**RFI**

RFI #: 79  
 Date: 3/16/2012  
 Job: EB-02 Keller Springs Lofts  
 Phone: 877-777-5115

CC: Jordan & Skala Engineers, Inc. (Dallas)  
 Subject: Penetrations in structural beams

RFI #: 84  
 Date: 3/23/2012  
 Job: EB-02 Keller Springs Lofts  
 Phone: 877-777-5115

SHEET NUMBER
S2.16

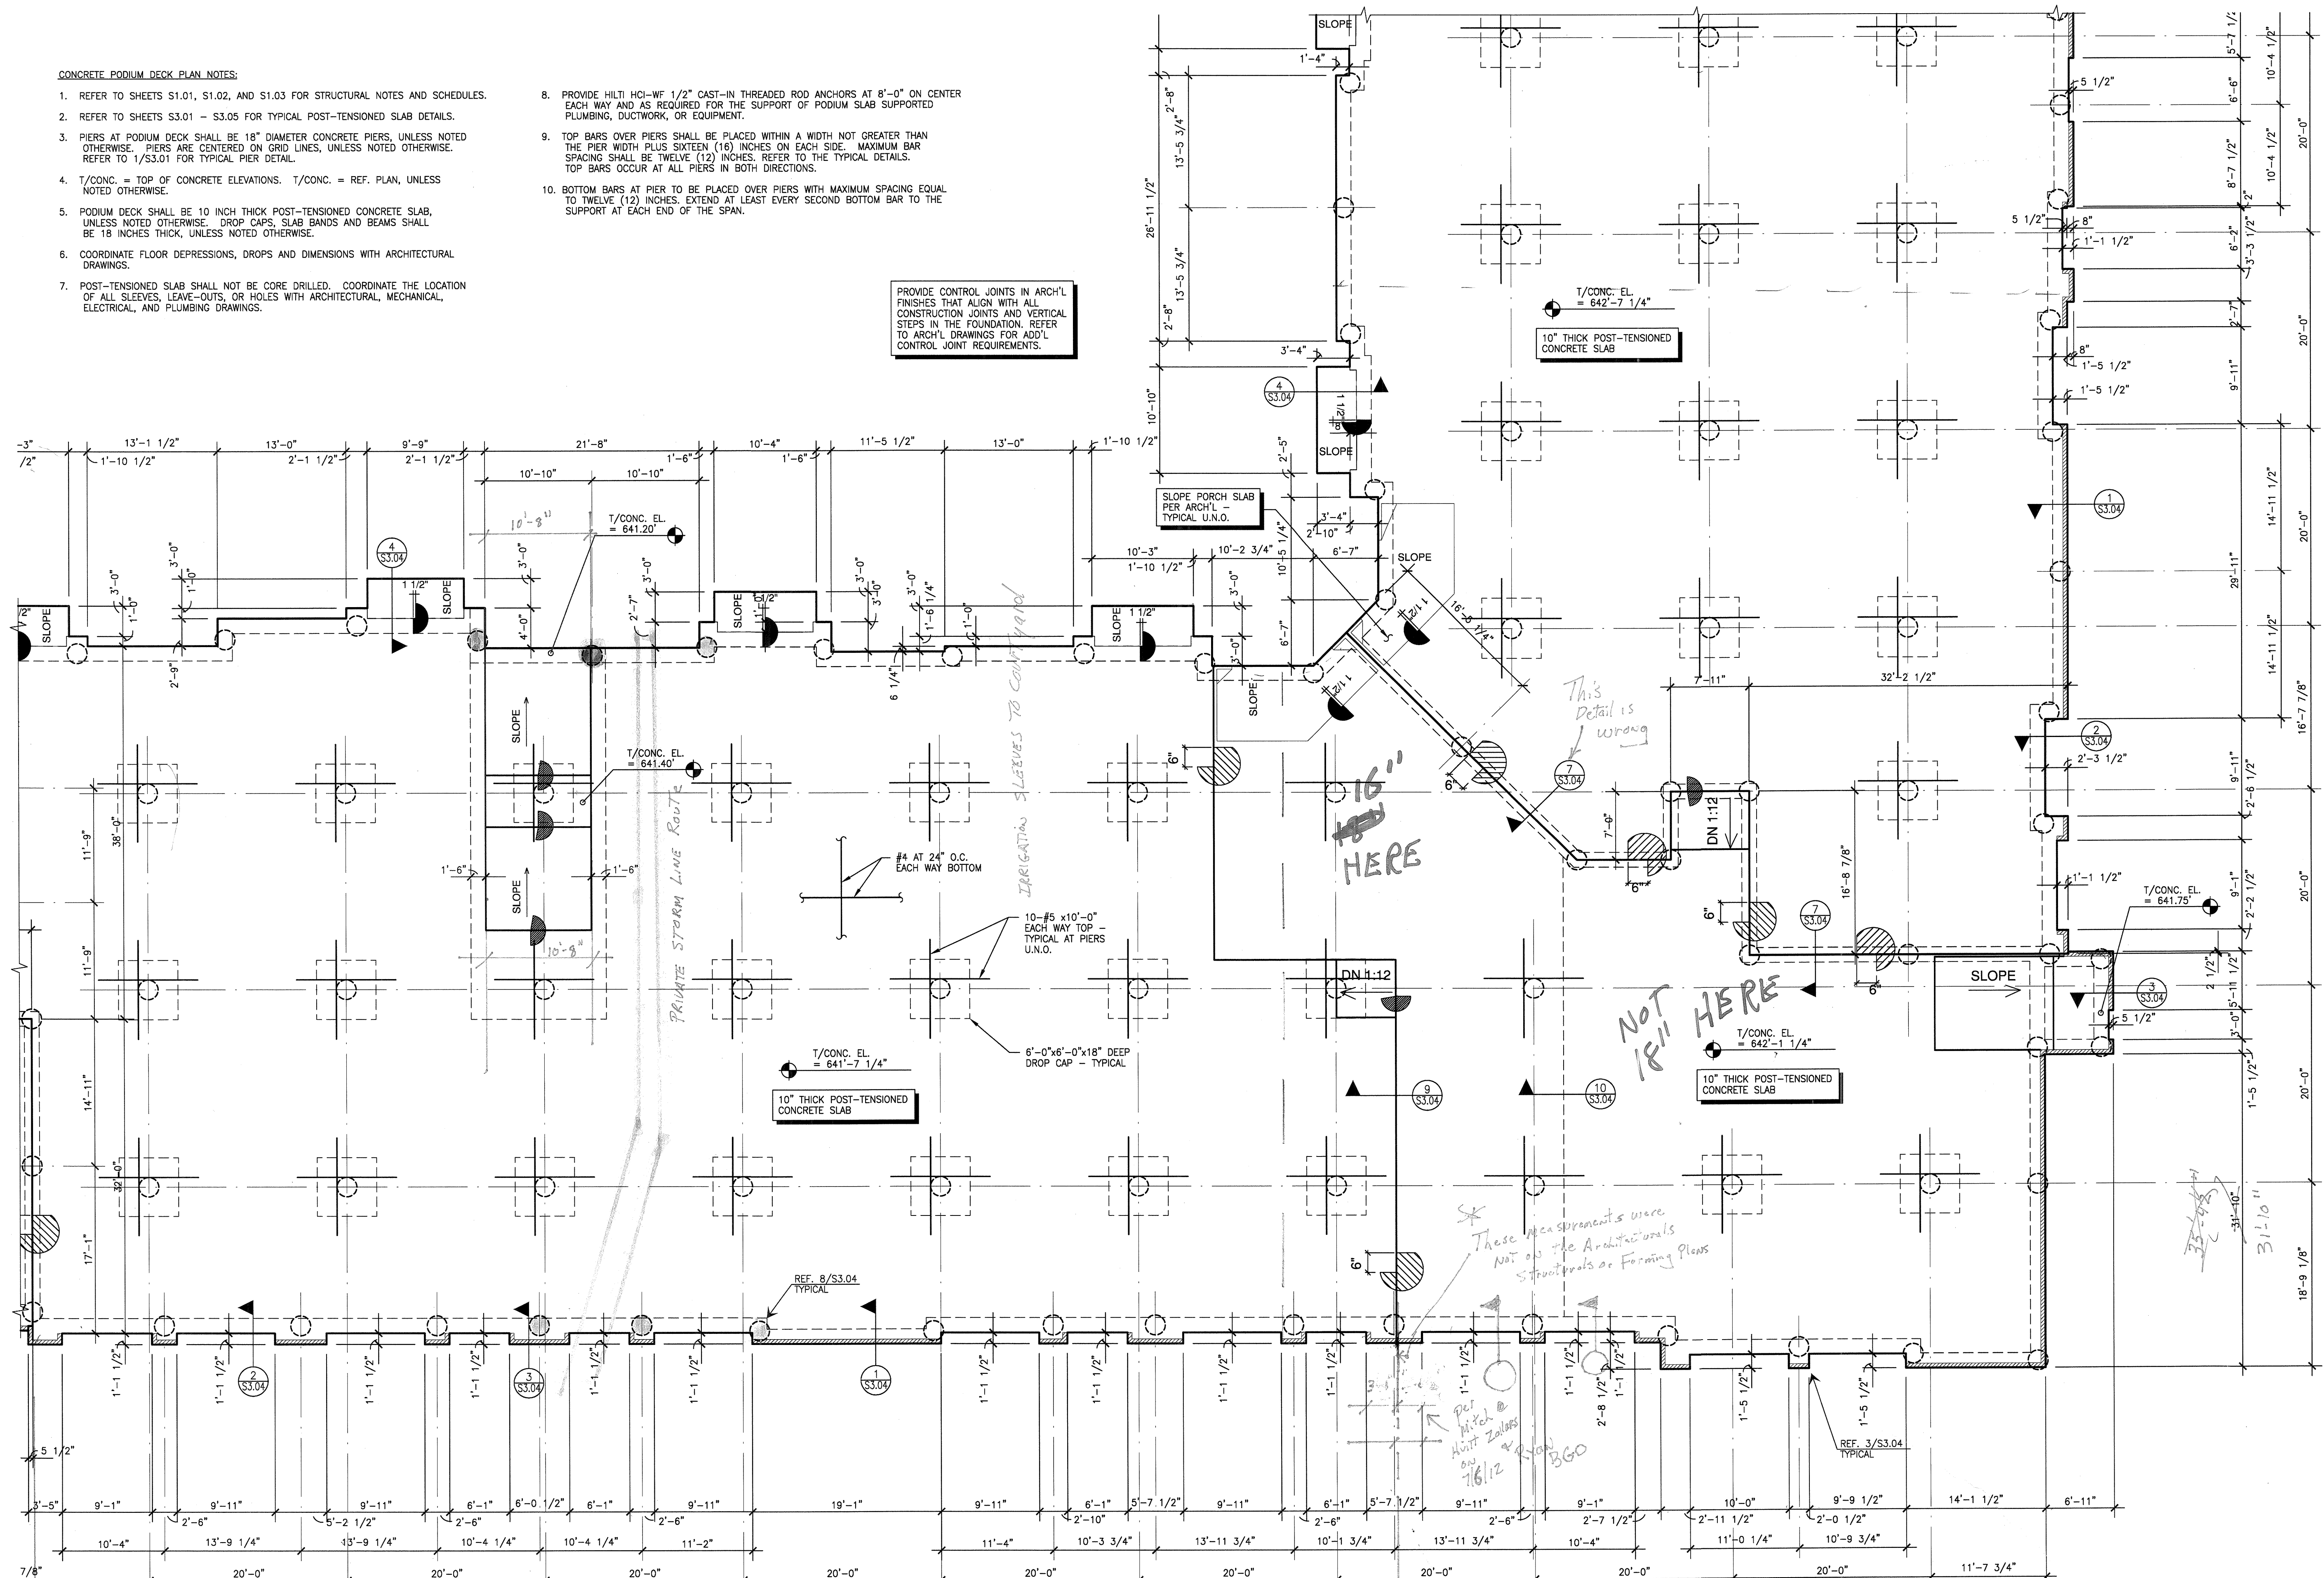
Request: Date Required: 3/13/2012  
 Please provide the appropriate details and procedures for the placement of plumbing pipes in the structural beam locations shown on the included attachment. The beams that are marked on the attachment will all have plumbing stacks located in them, as the beam is located under a party wall in which plumbing is located

Response:  
 See attached detail for penetrations.  
 R. Trent Perkins, PE  
 Principal March 13, 2012

NOTE:  
 1. PROVIDE ADD'L REINFR PER 4/S3.01  
 2. DIAMETER OF SLEEVE SHALL BE 1/2" LARGER THAN PIPE MINIMUM.
